From: Phil Hamblin [REDACTED]
Sent: 19 July 2021 14:35
To: Maria Tomalova <Maria.Tomalova@arun.gov.uk>
Cc: Daniel Vick <Daniel.Vick@arun.gov.uk>
Subject: FW: Planning Consultation on: AL/66/21/PL

Engineers Comments Regarding Surface Water Drainage

Appendix 1- drainage in relation to RPAs

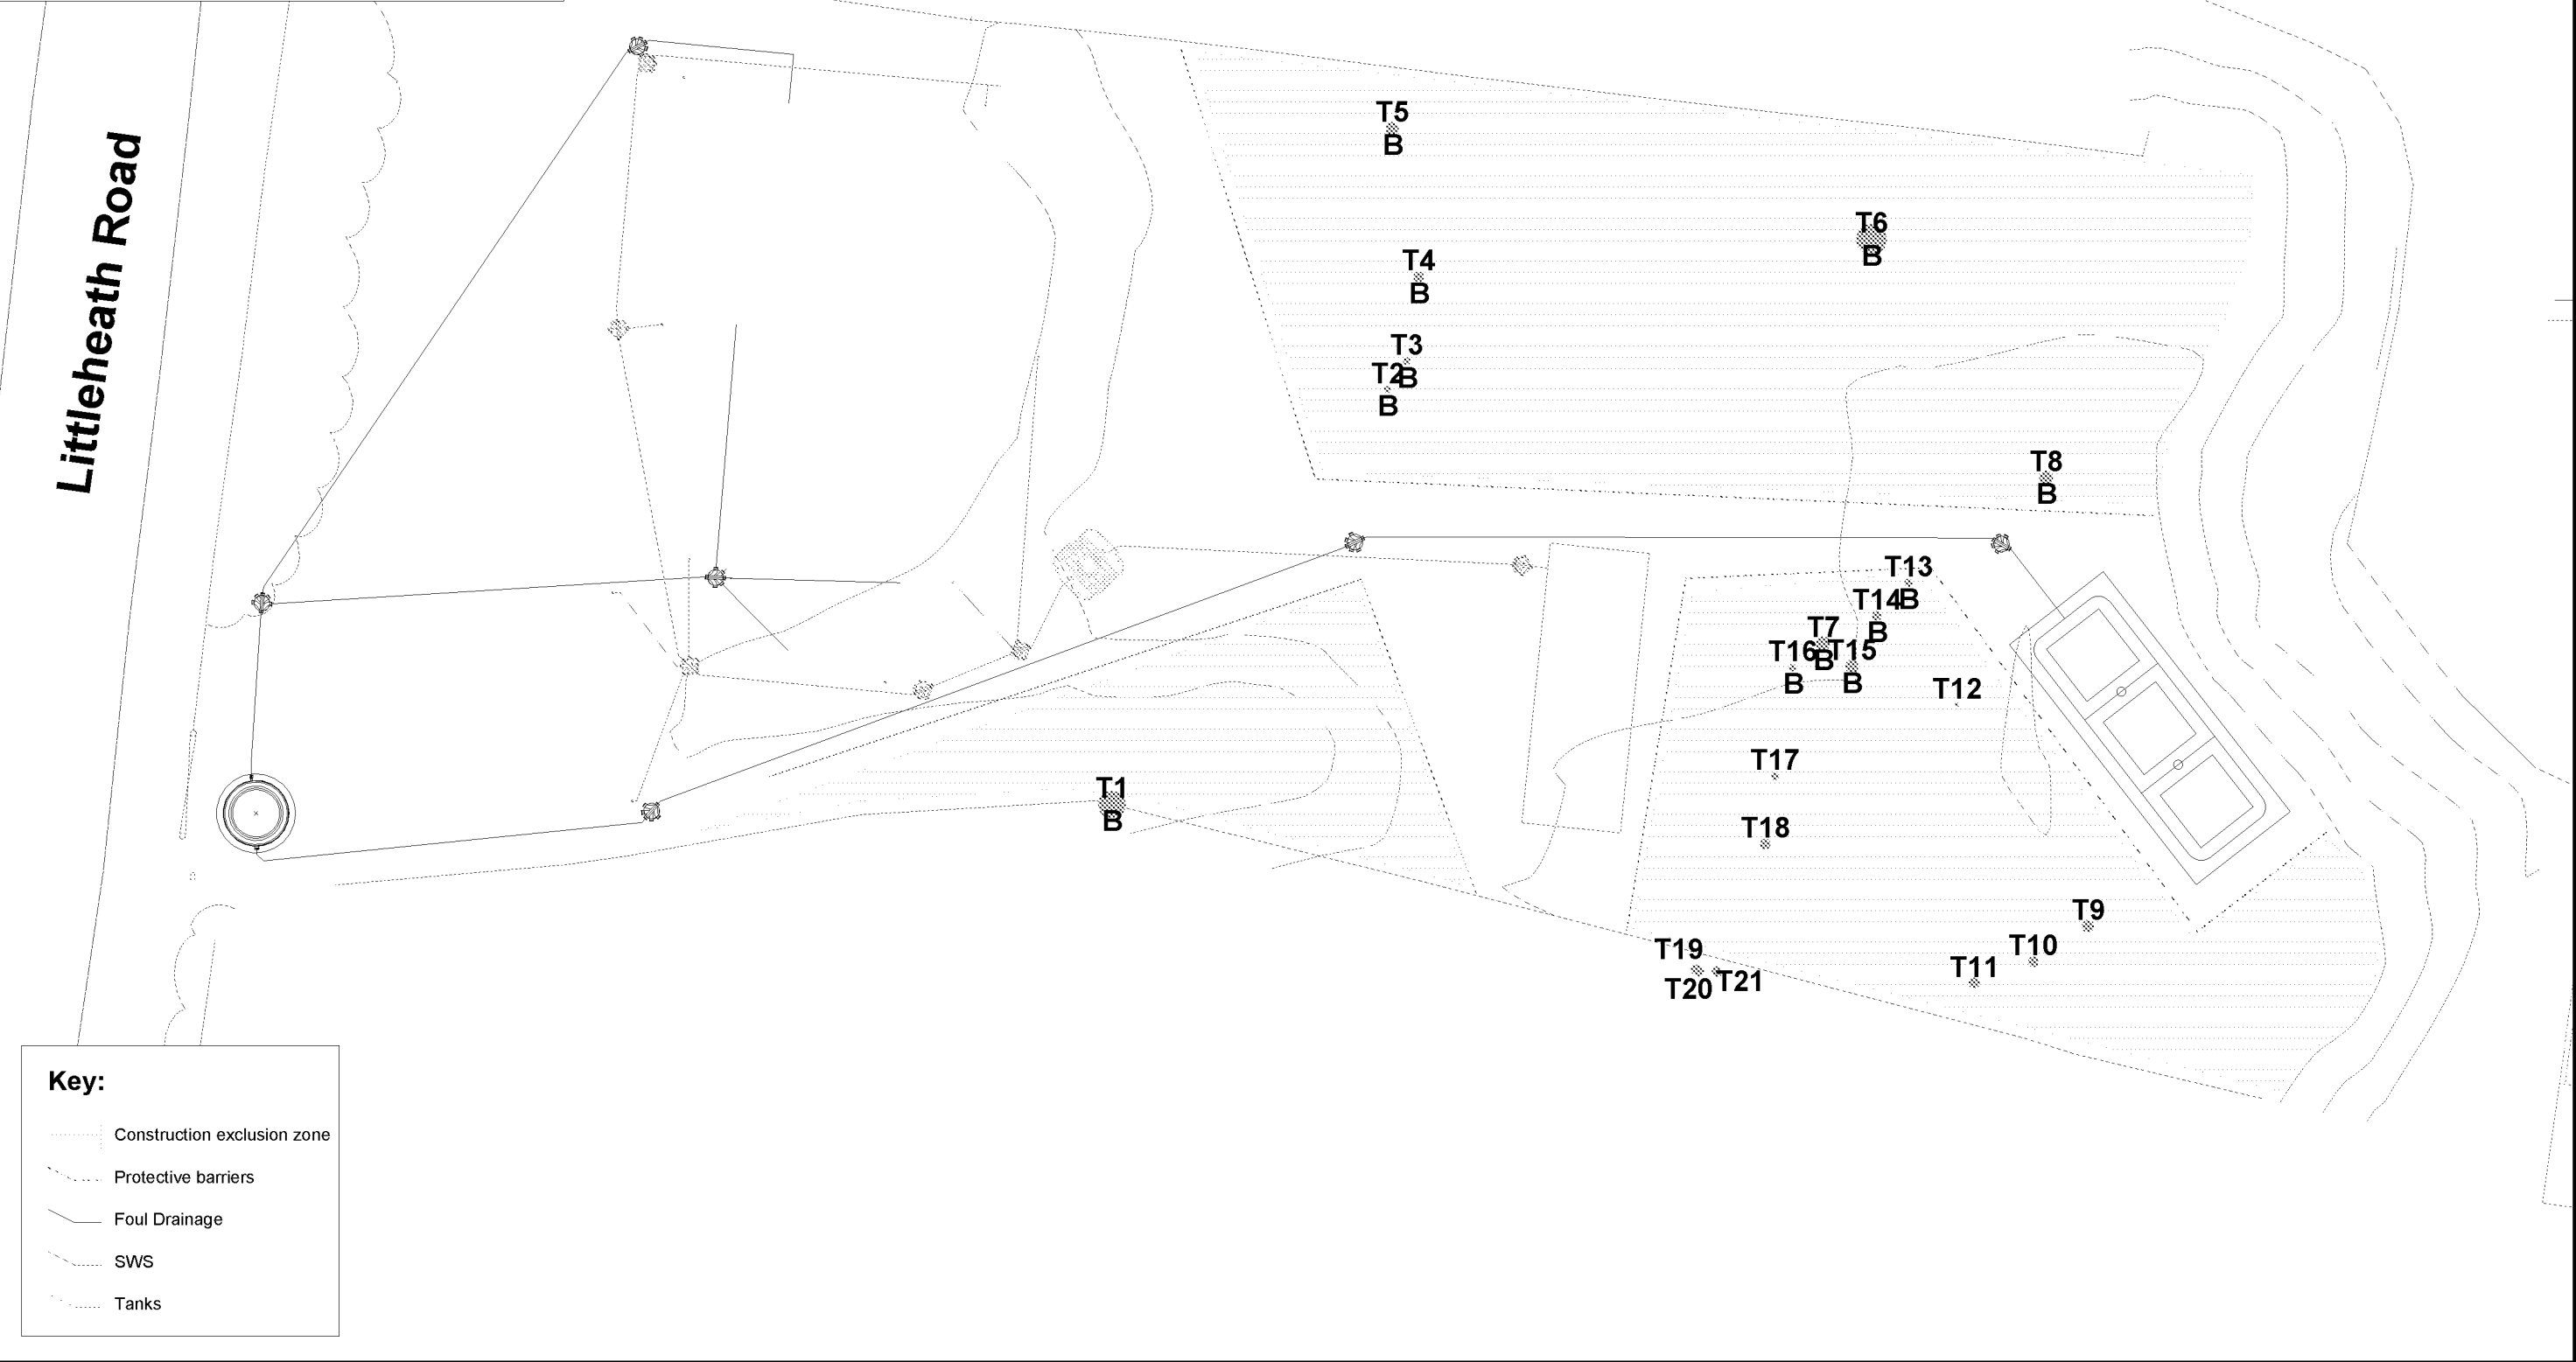
Please consult the Tree Officer for his opinion on the siting of the proposed soakaway (it's proximity to the existing Alder which is being retained offsite) and the proposed measures described in the Arboricultural Addendum to mitigate tree root damage.
